PLANNING DEPARTMENT – Development Review Services

**RE: Indian Cycle Dealer, 4508 Alameda Blvd. NE  
Grading & Drainage Plan For Grading and Paving Permit  
Engineer's Stamp Date 7-14-2014 (File: C17D002A22)**

Based upon the information provided in your submittal received 7-17-14, the above referenced plan cannot be approved for Grading Permit and Paving Permit until the following comments are addressed:

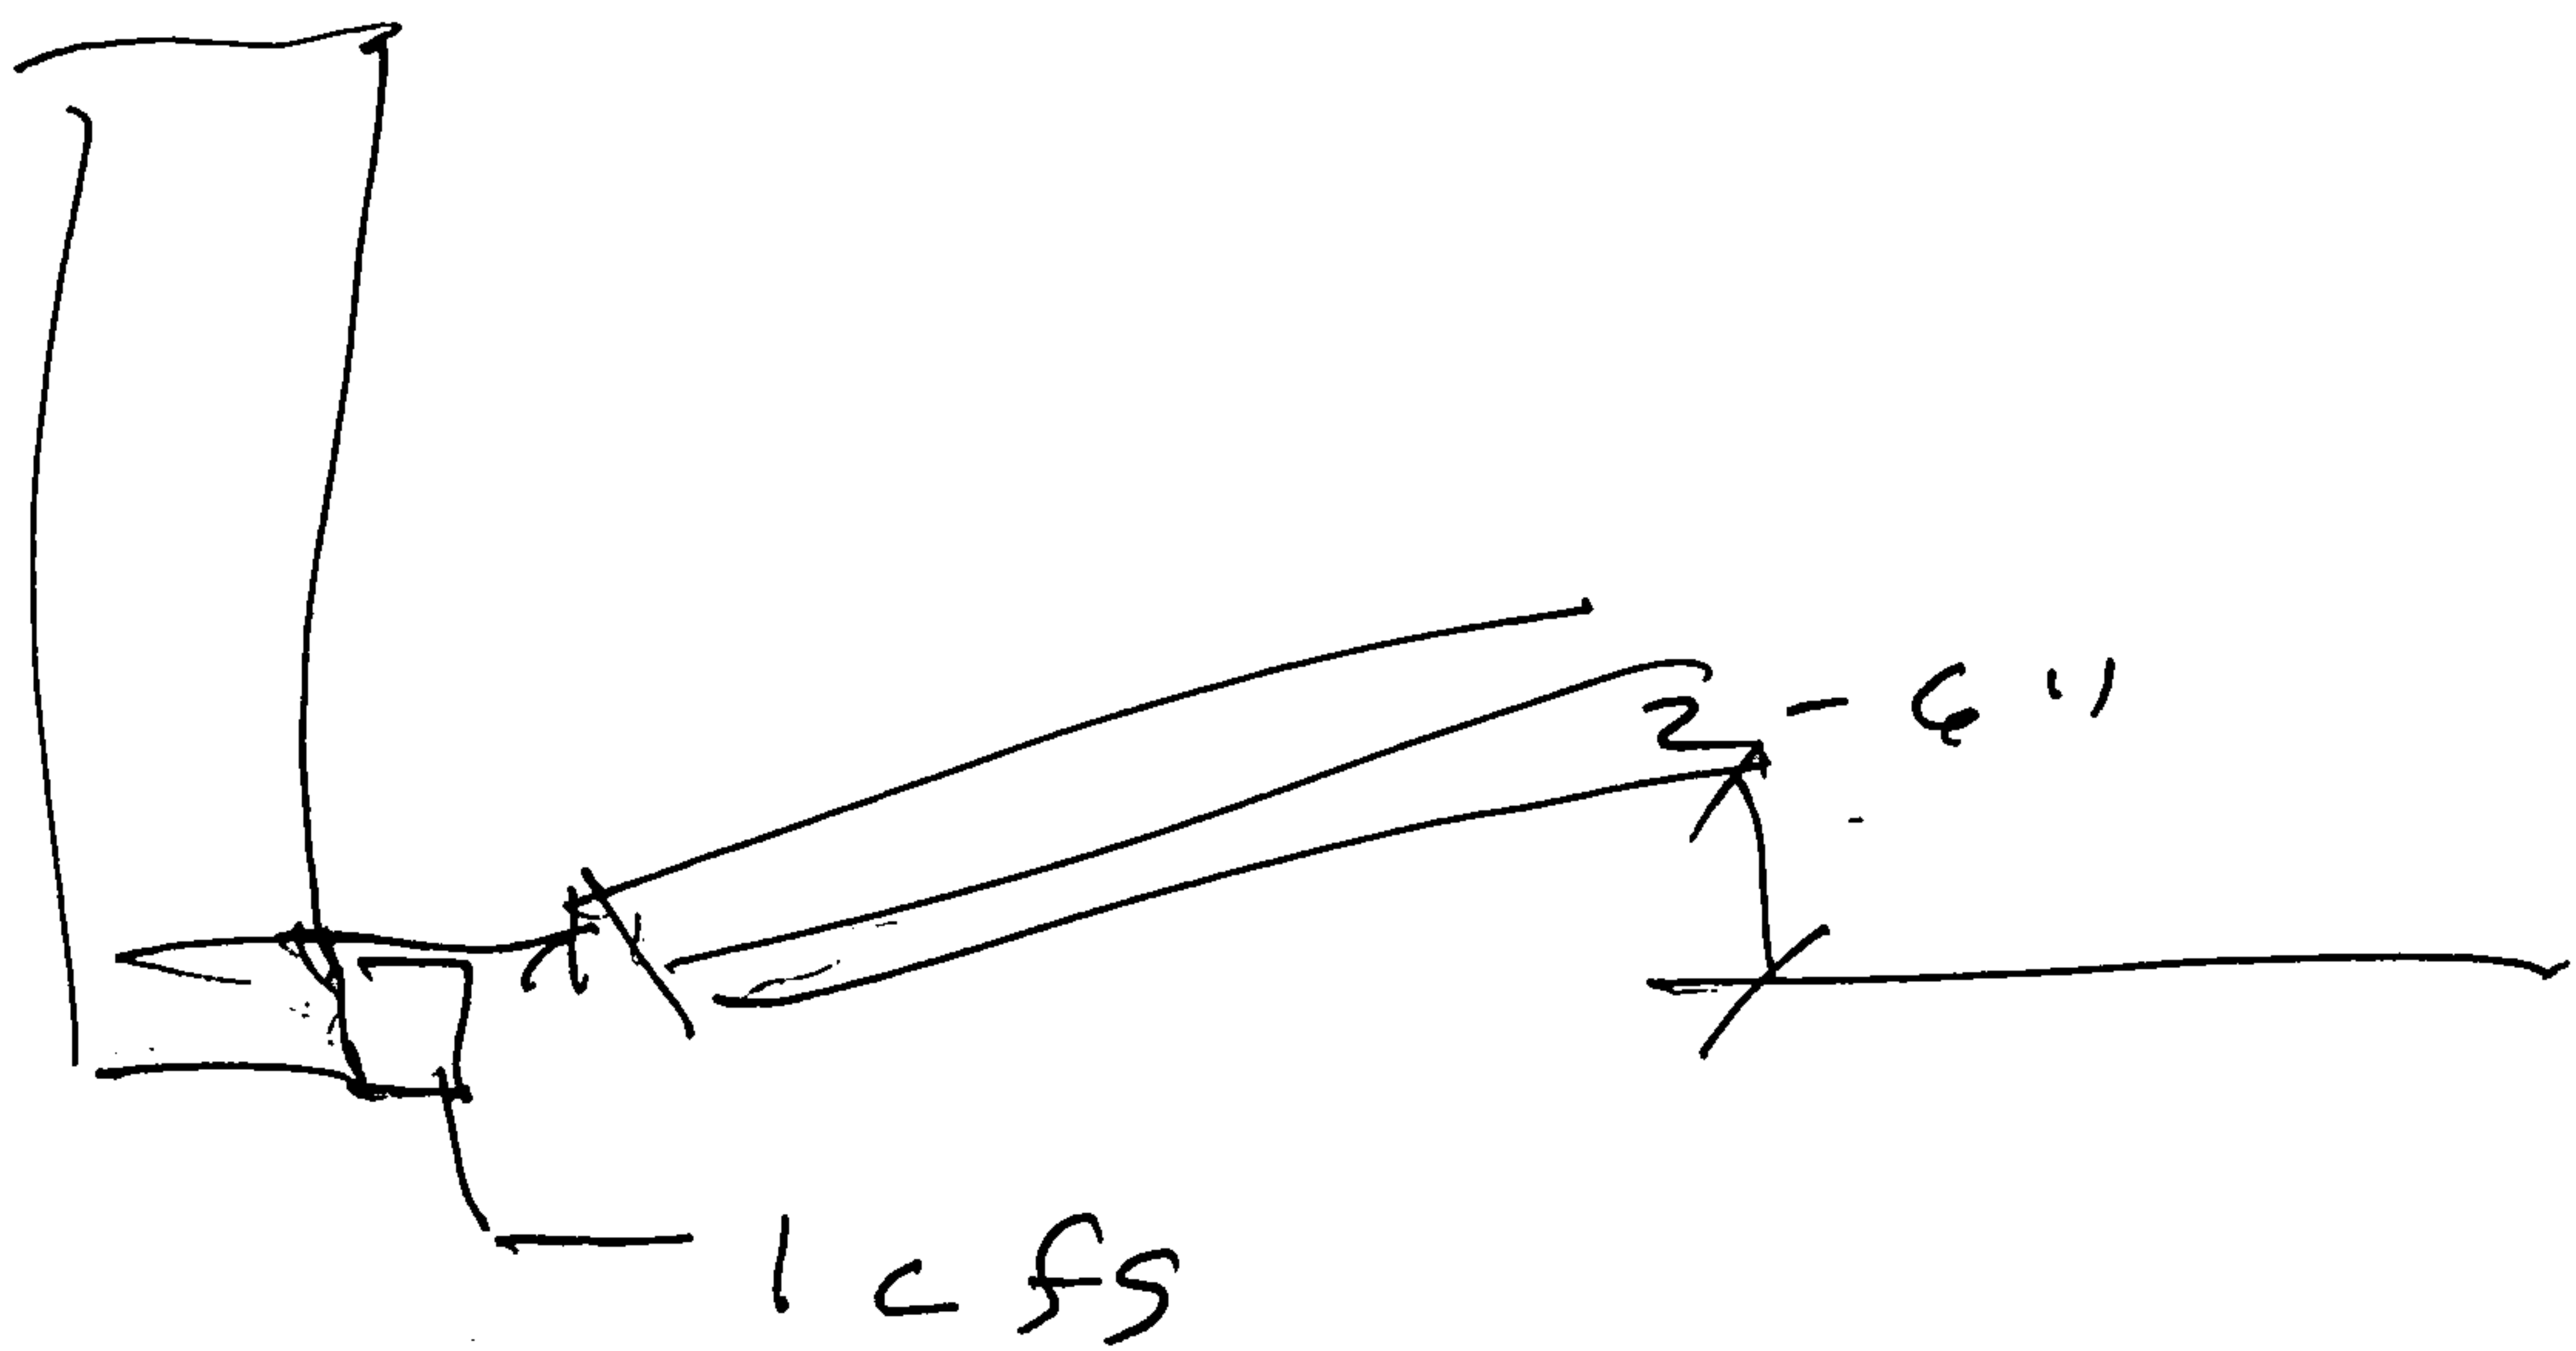
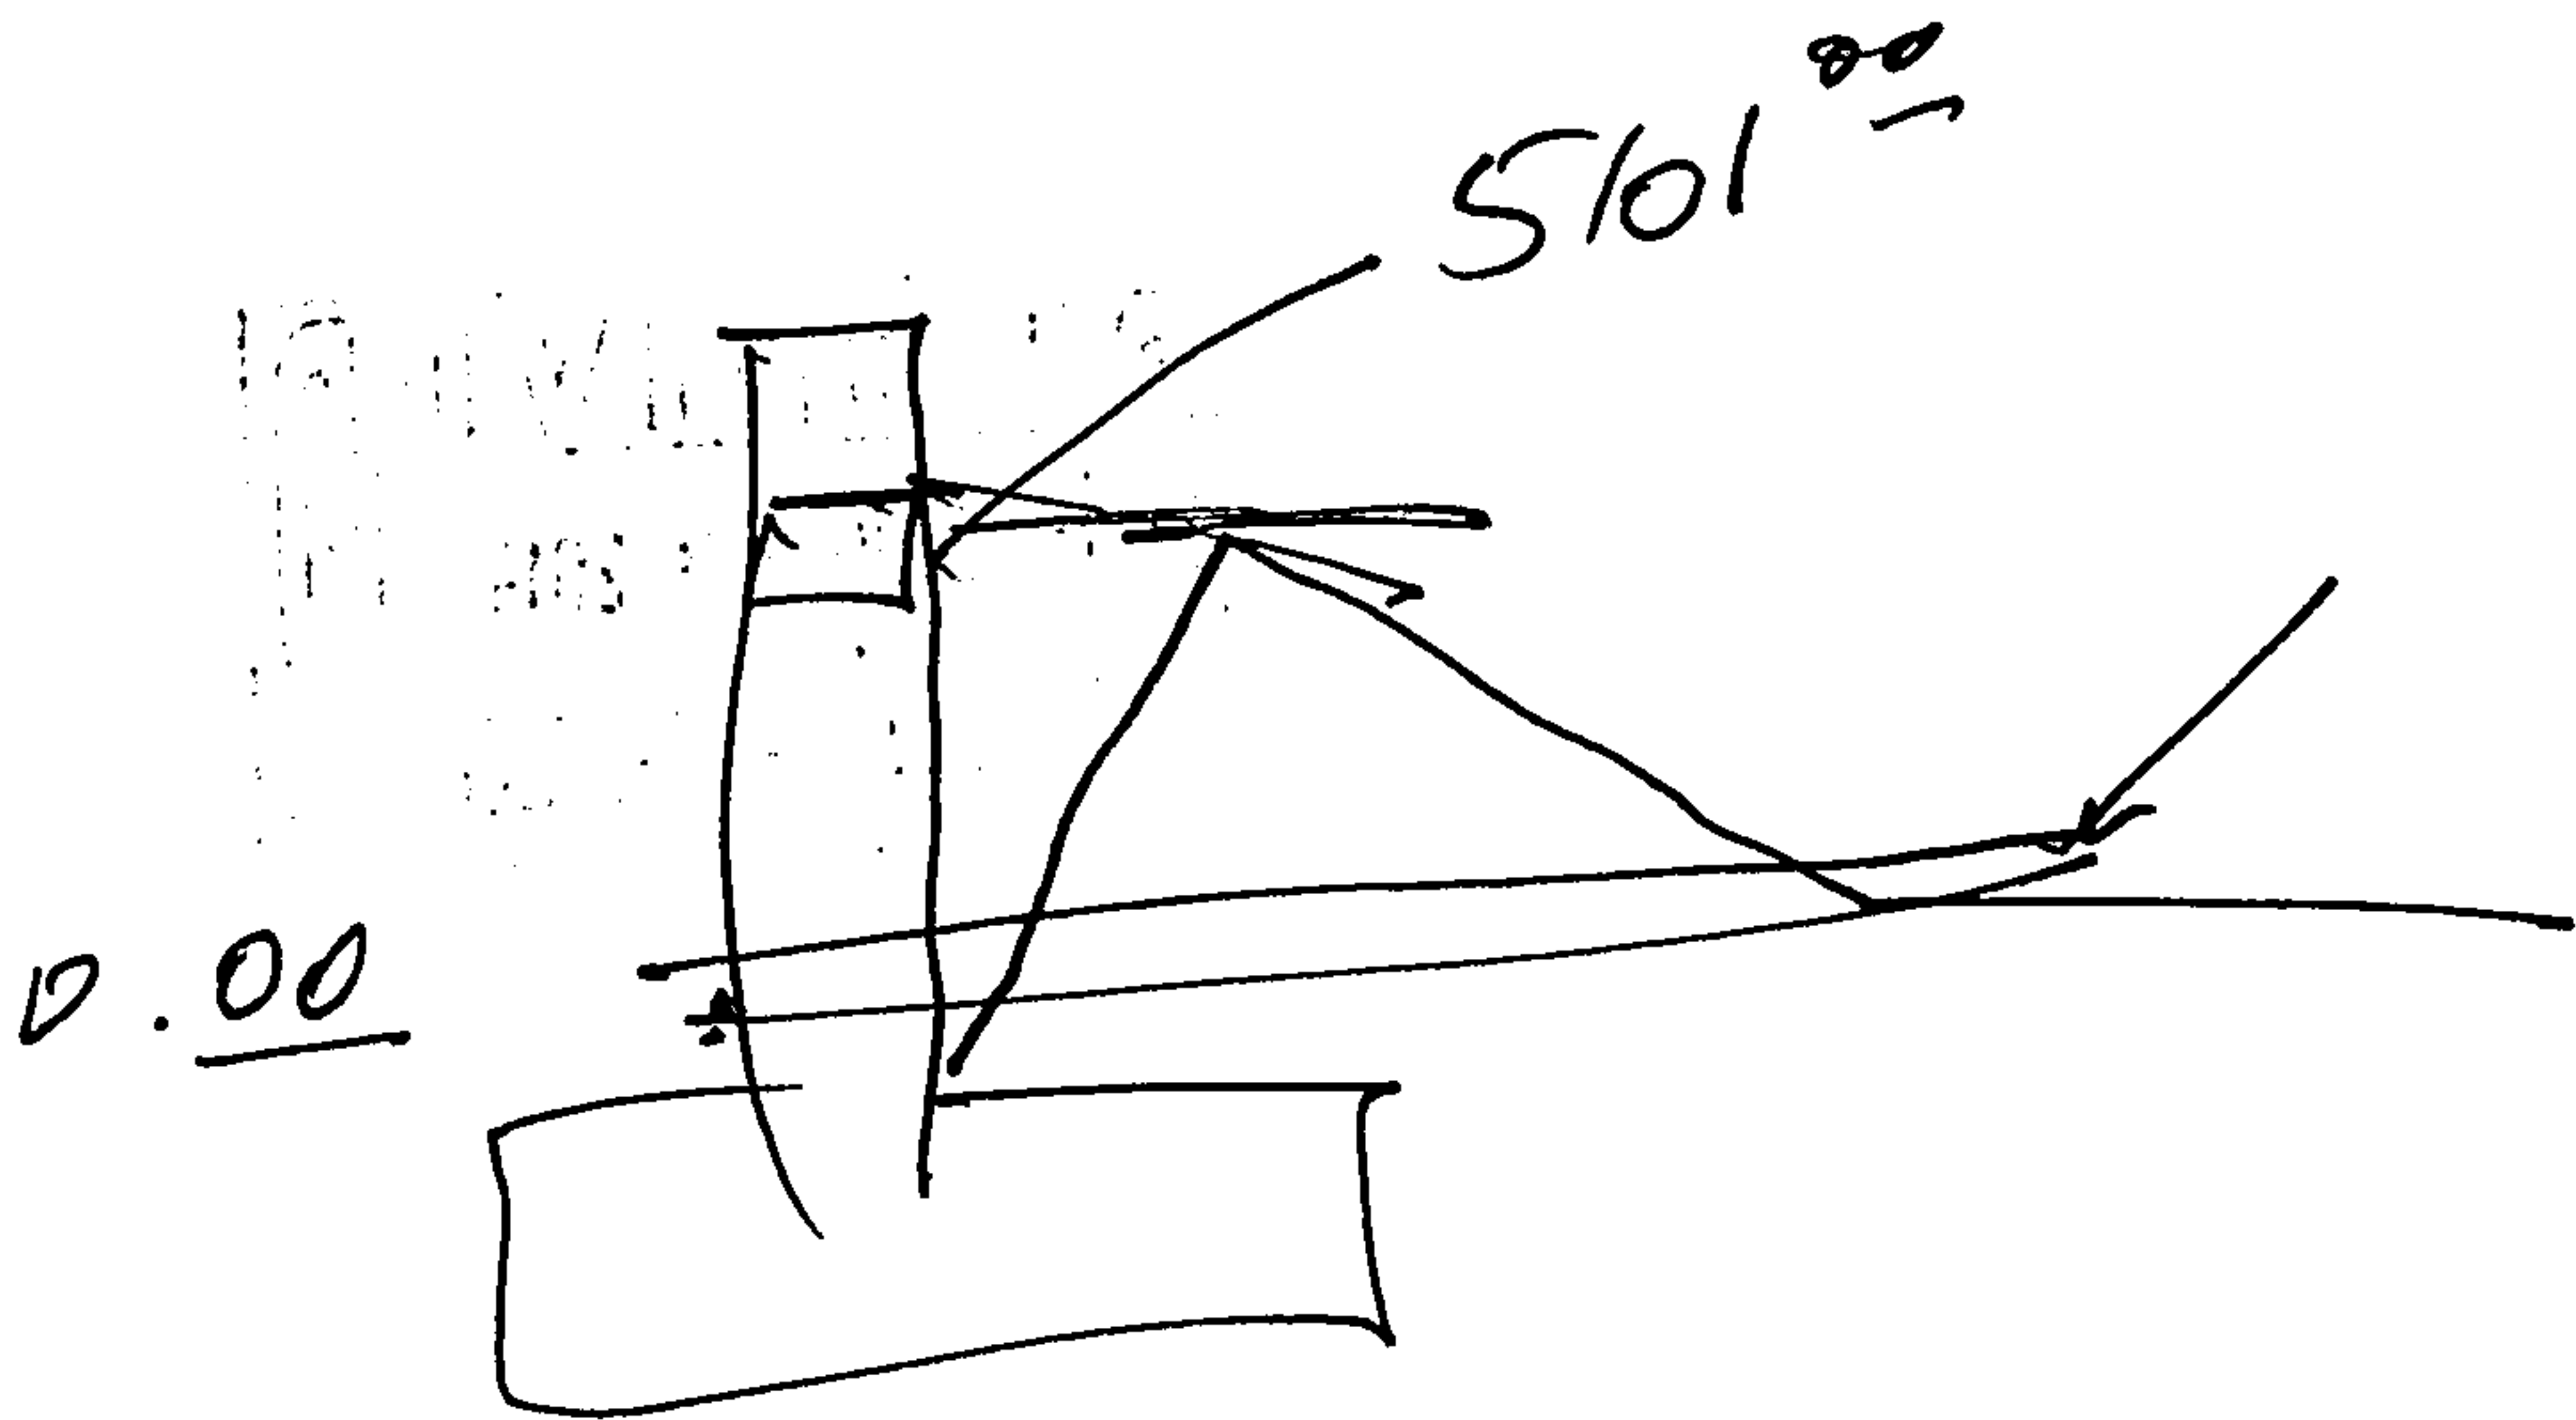
- The hydrograph substantiates the pond volume *only* where the discharge is 2 PVC pipes, and not for the rectangular discharge weir. Therefore, do not include it as an option, and remove the section detail unless calculations are provided to support its use.
- The following comments were not addressed from the previous comment letter:
- Pond Contour lines are unclear at the rim. What are the elevations at the corners of the Top of Pond. A spot elevation of 3.60 is shown where the contour indicates it is 2.50 ft. at the east end of pond.
- Indicate in the narrative that the site is adjacent to an AO flood zone in Alameda.
- West side of site has an existing rundown that appears to be removed. How will flow be diverted to pond? Show spot elevations to show that once the landscape buffer is saturated, flow is diverted to pond.
